A63 Castle Street Improvements, Hull Environmental Statement

**Volume 3 Appendix 4.1
CONSULTATION – RESPONSE TO PINS AND STAKEHOLDER
SCOPING OPINION COMMENTS**

**TR010016/APP/6.3
HE514508-MMSJV-EGN-S0-RP-LE-000030
31 July 2018**

APPENDIX 4.1A: Response to PINS & Stakeholder Scoping Opinion Comments

Drawing Title: **VOLUME 2 FIGURE 2.5.5 THE SCHEME PROPOSALS - SHEET 4 OF 6**

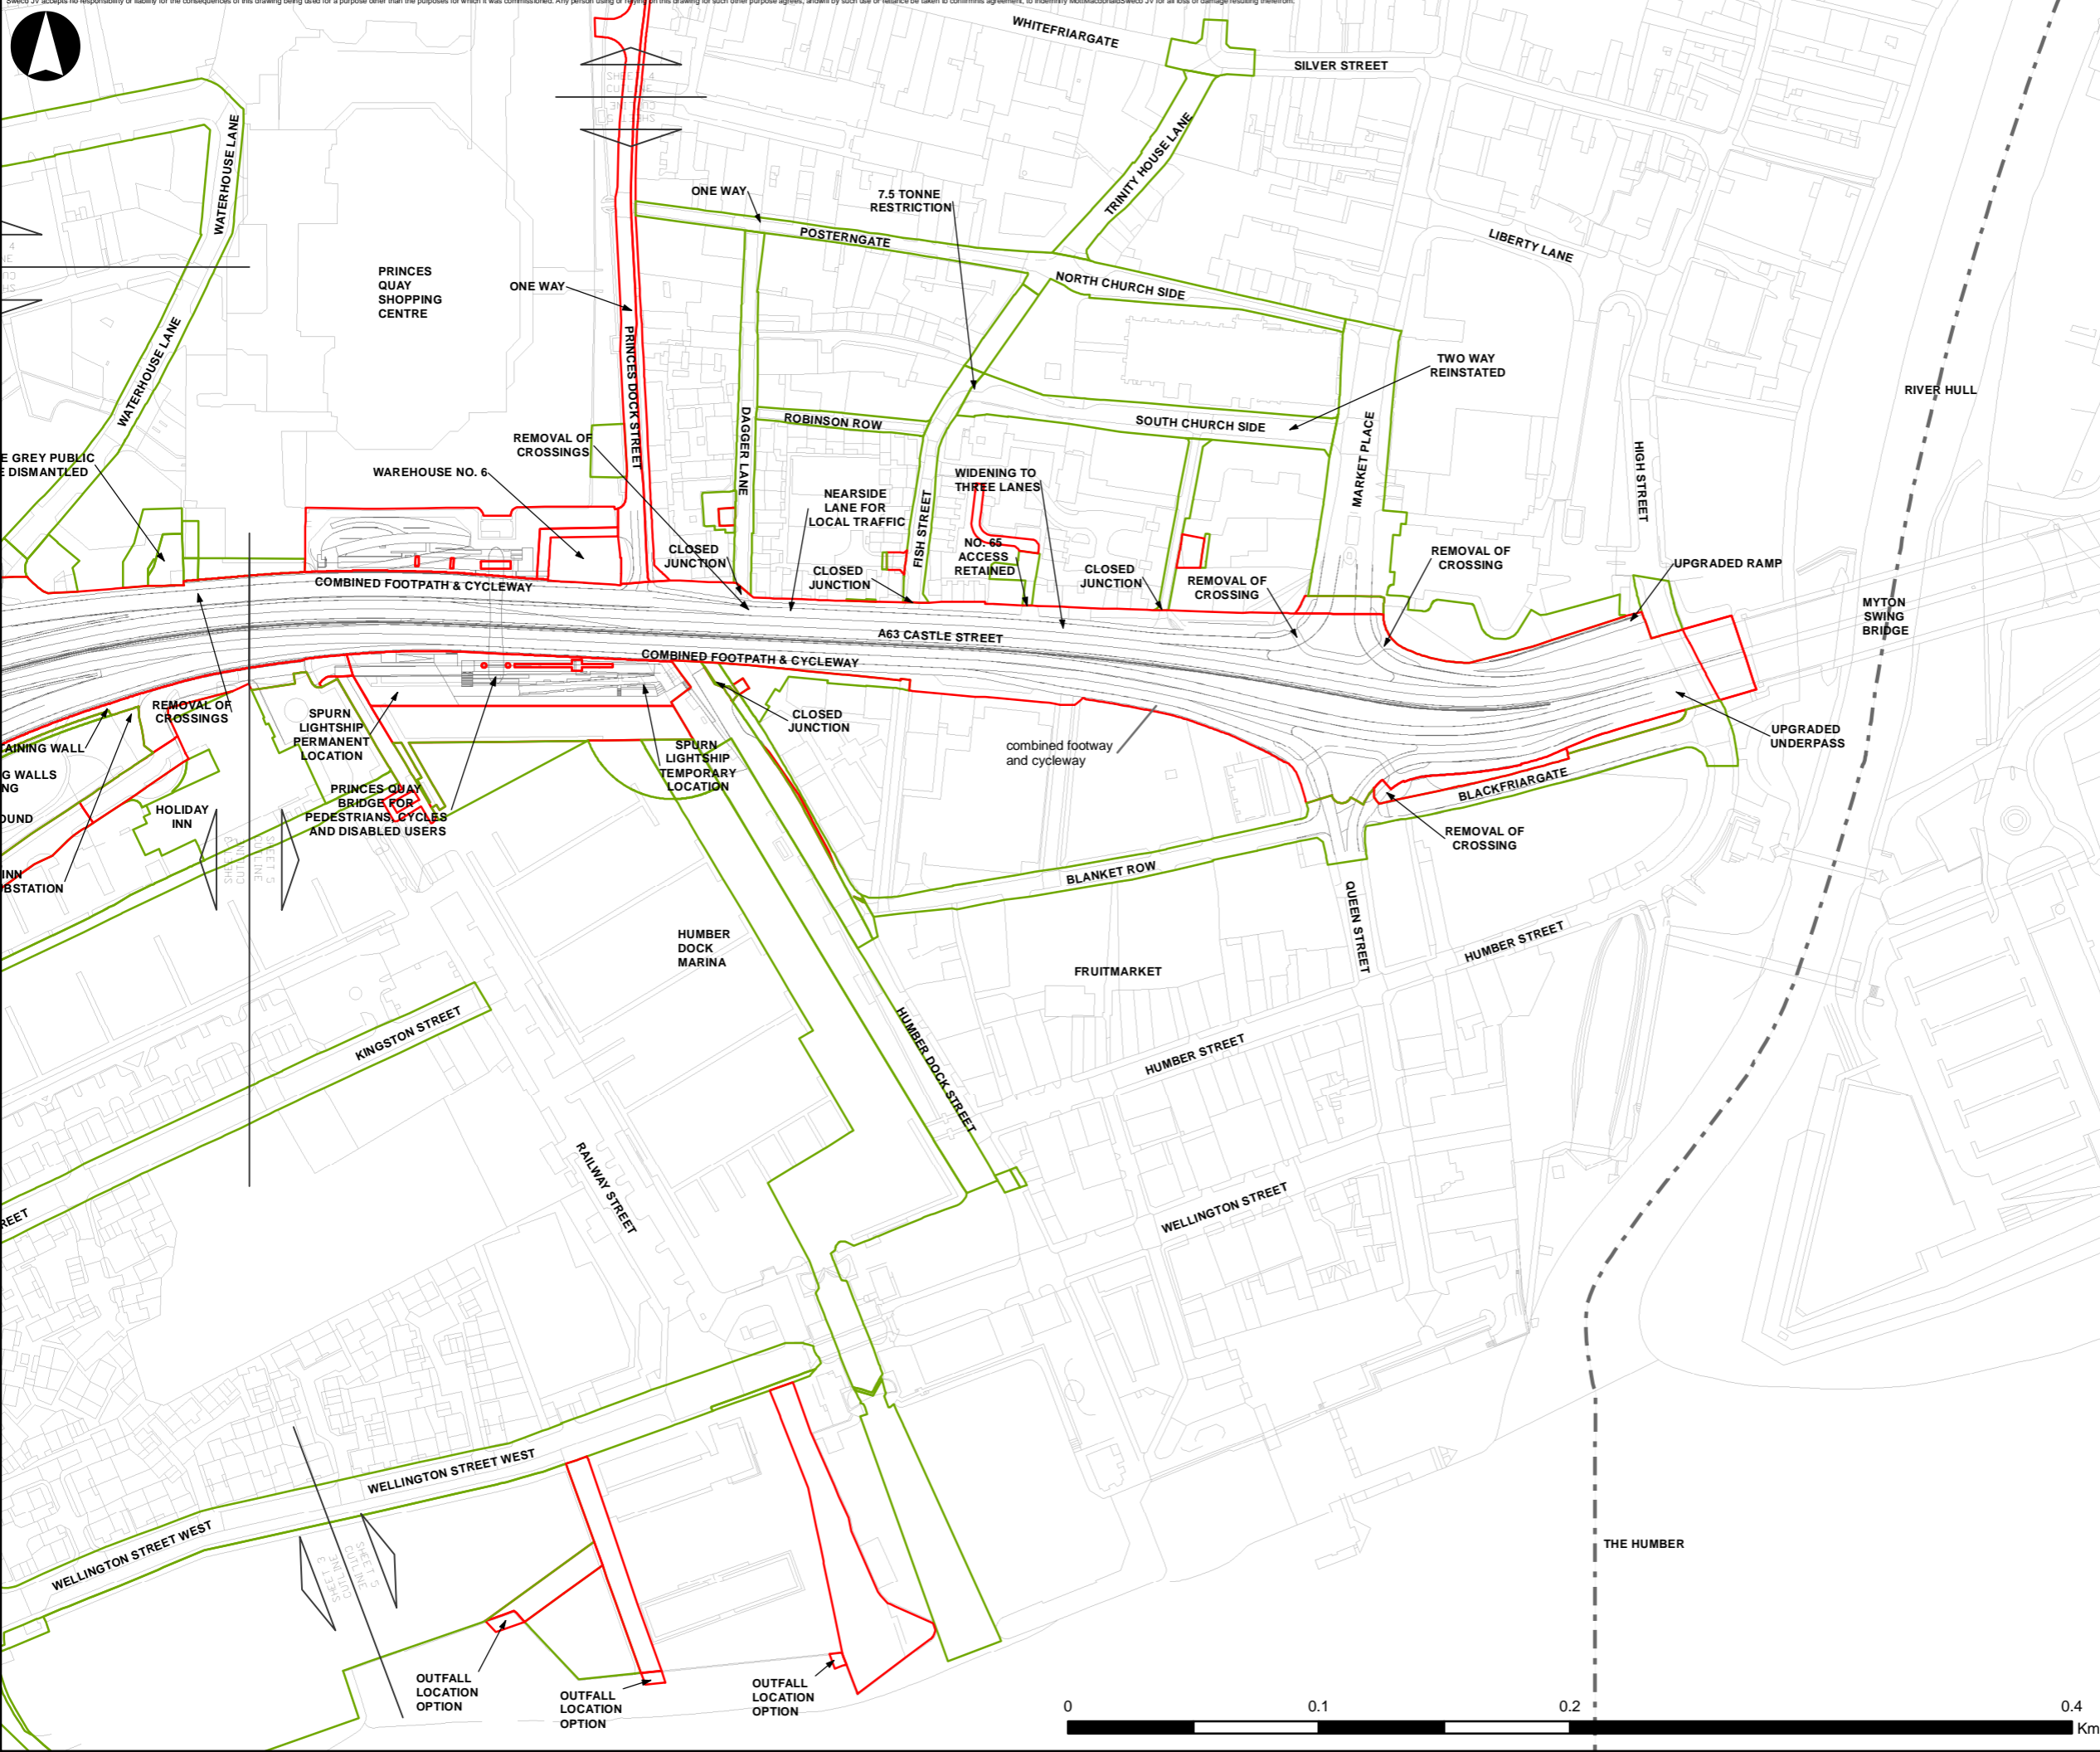
2.38	Potential land requirements for the construction phase are illustrated in Figure 1E in Appendix A of the Scoping Report. These areas are not included within the red-line boundary of the development as shown on this plan. The DCO boundary should encompass both temporary and permanent land requirements.	Include temporary and permanent landtake (including compounds) within DCO red line boundary	AS	Details of permanent land take, permanent rights and temporary land take boundaries can be found on Figures 2.5.1 to 2.5.7: Scheme Proposals.

Drawing Title: VOLUME 2 - FIGURE 2.11.2 TEMPORARY TRAFFIC MANAGEMENT PHASE 2

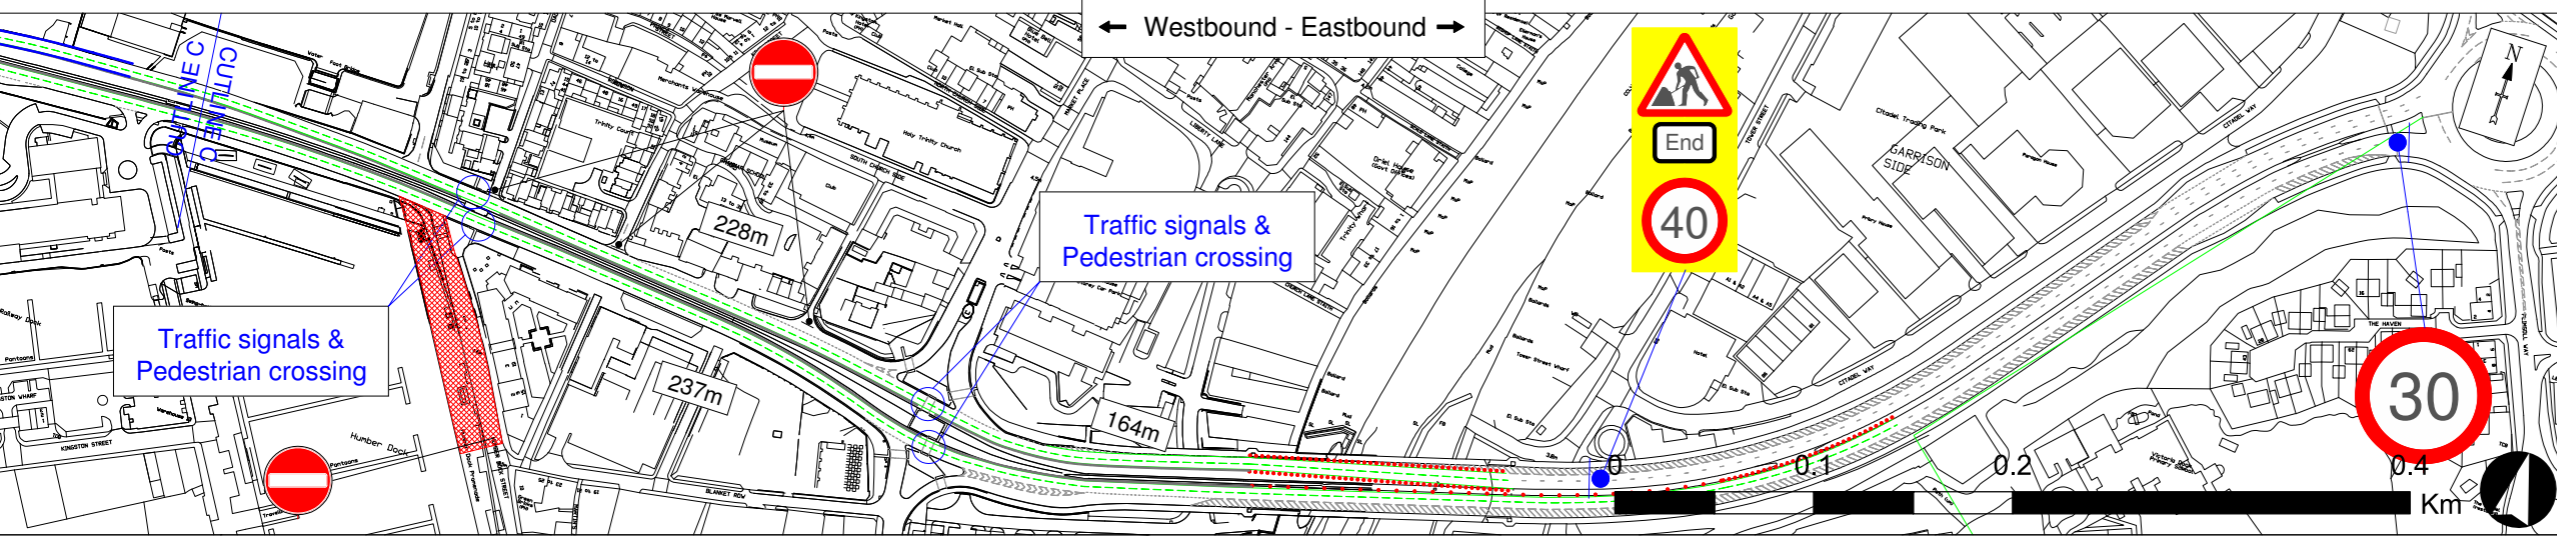
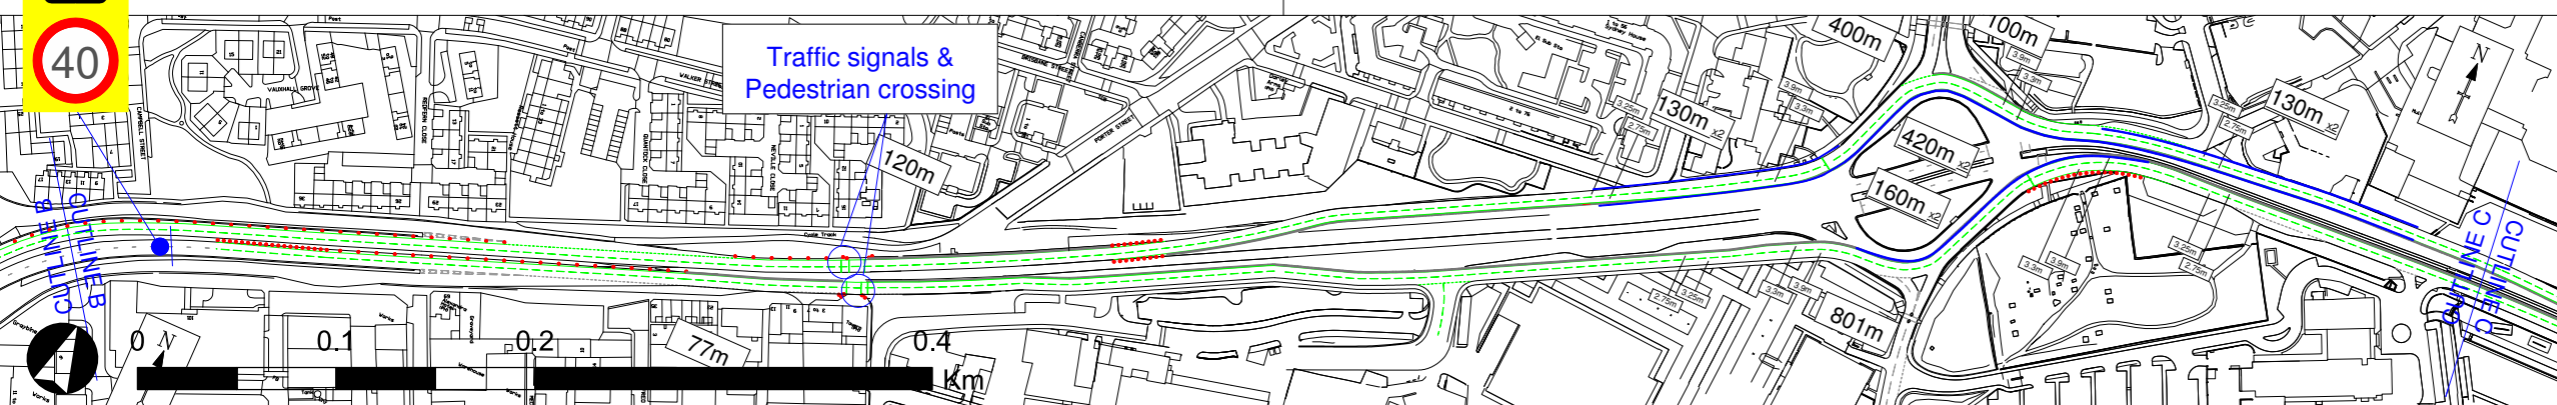
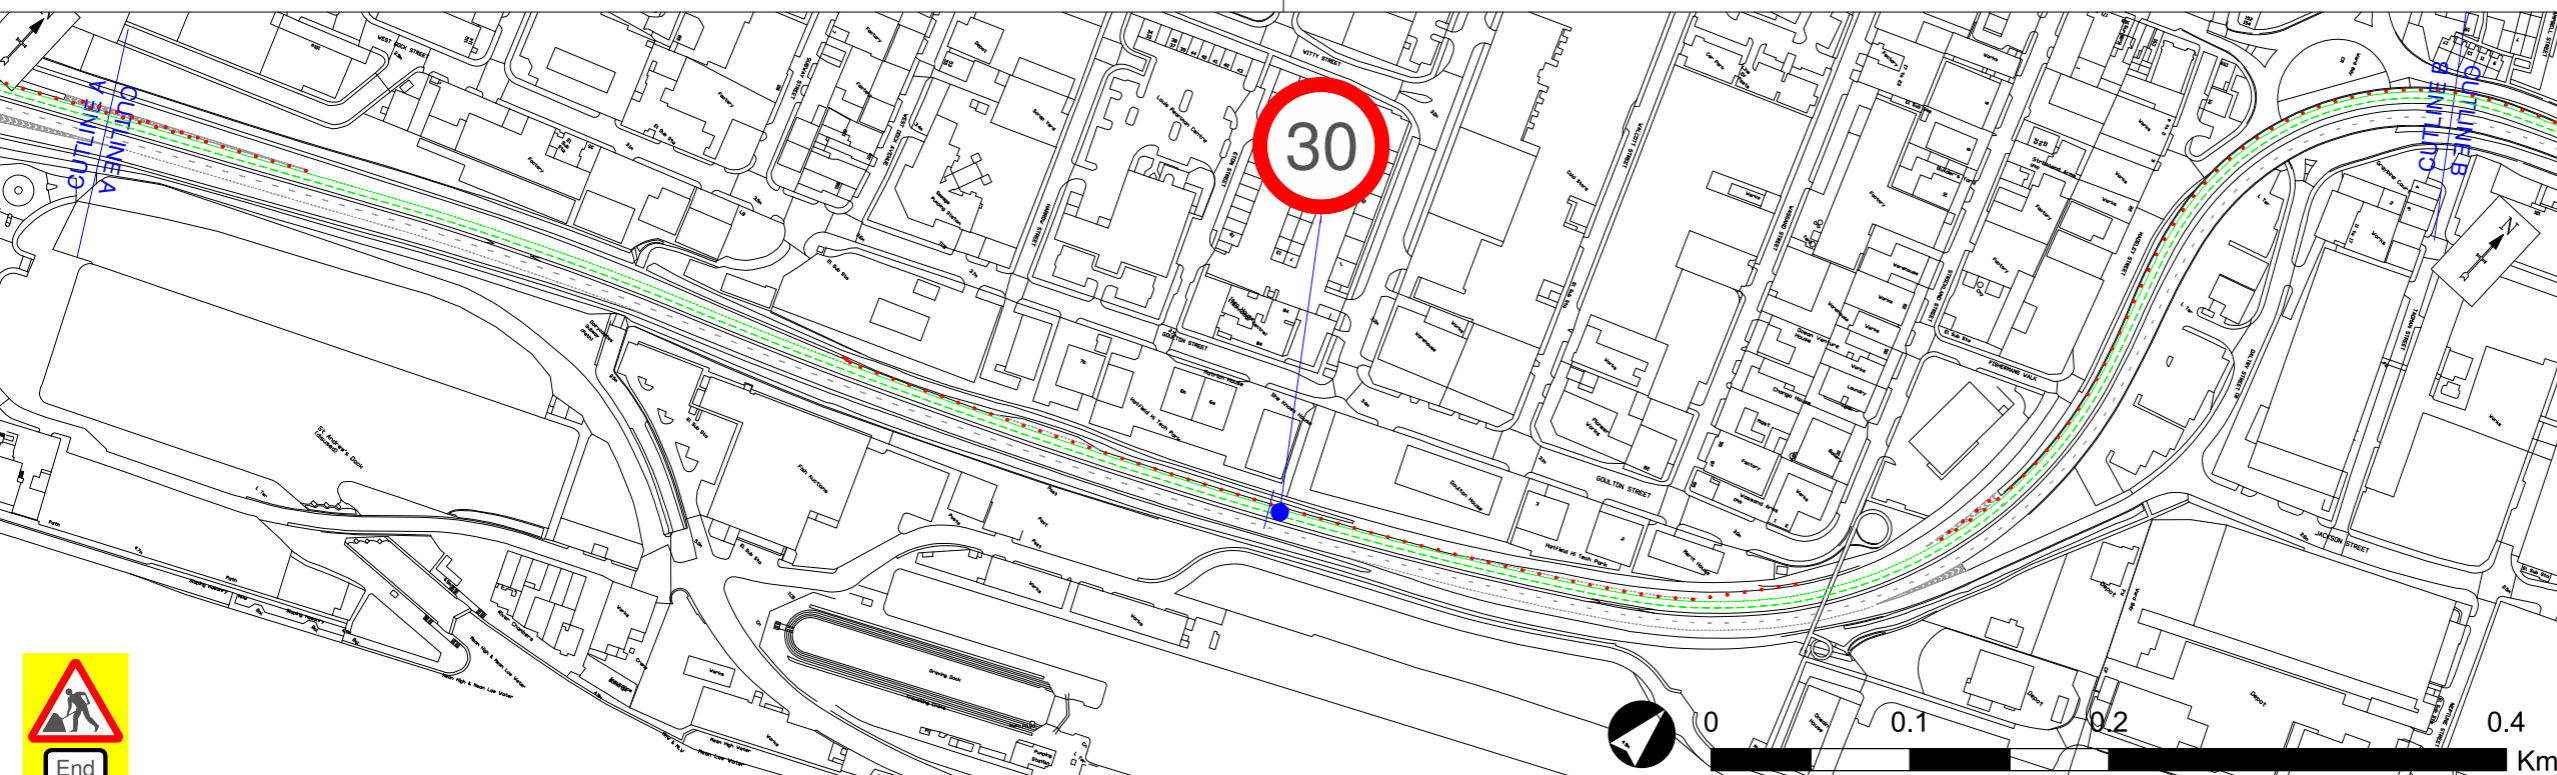
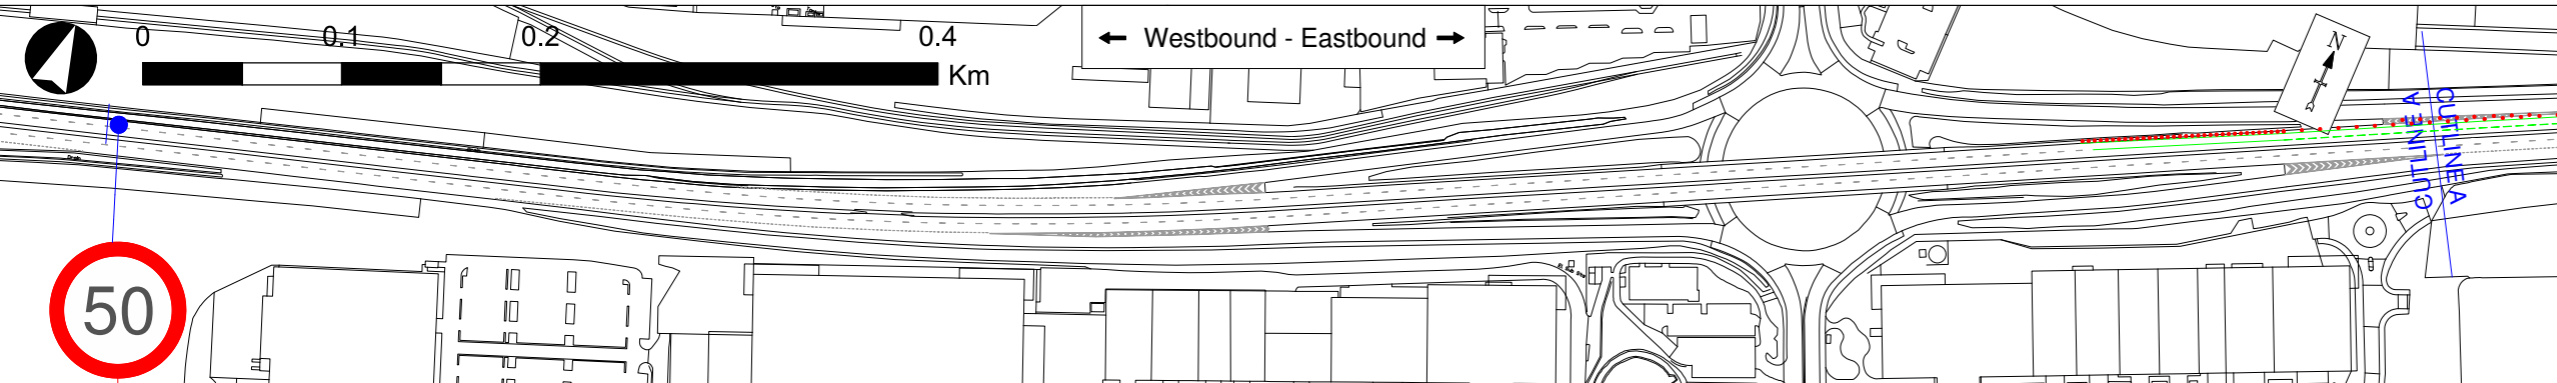
2.26	The Scoping Report does not describe how construction vehicles would access the development and which routes would be used to transport plant and materials to and from the site.	Consider in ES. Vehicle access points and routes need to be defined.	AS	As confirmed in Chapter 2 The Scheme - Construction traffic would use the existing local road network to access the site and compounds. No temporary haul roads would be constructed. Details of traffic management during construction can be found on Figures 2.11.1 to 2.11.7: Temporary Traffic Management Phases 0 to 7.			
Construction
